SUBJECT: Engineering Review Comment
Mountain View Electric Association Inc. (MVEA)

Project Name: Flying Horse North Filing No. 9

Project Number: SF2625

TYPICAL LOT EASEMENTS DETAIL
NOT TO SCALE

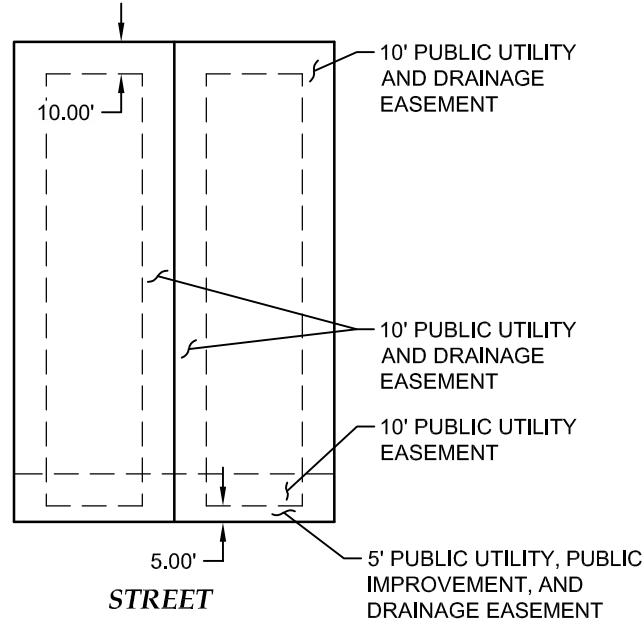
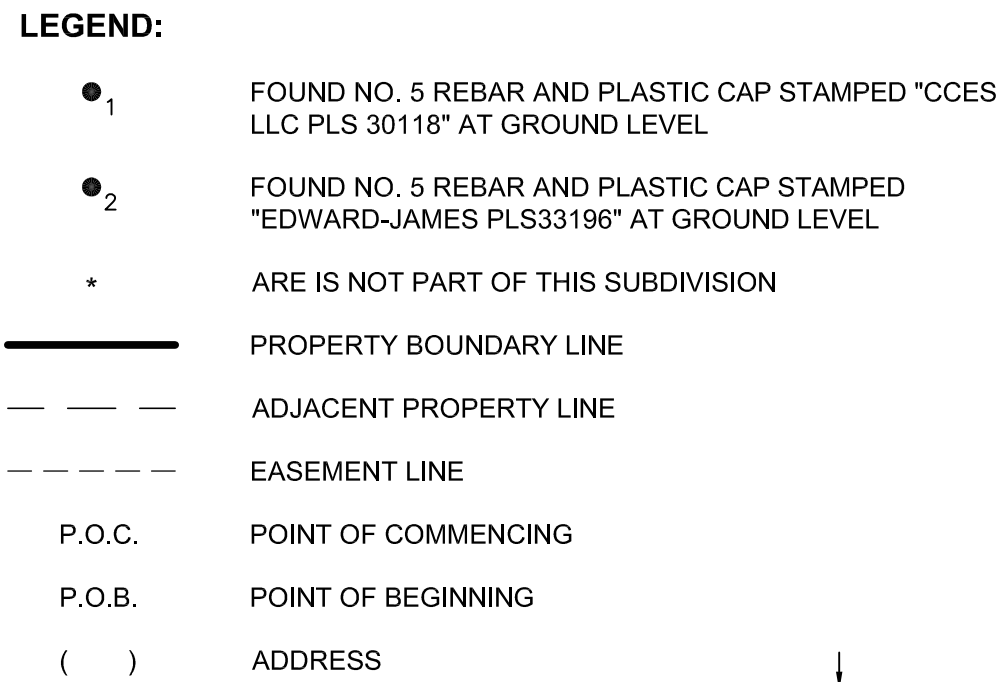
MVEA requests a ten (10) foot front, side, and rear lot utility easement and all tracts, along with a twenty (20) foot exterior utility easement on the plat. MVEA also requests the platting of MVEA's existing facilities with easements on the plat. Additional easements may be required.
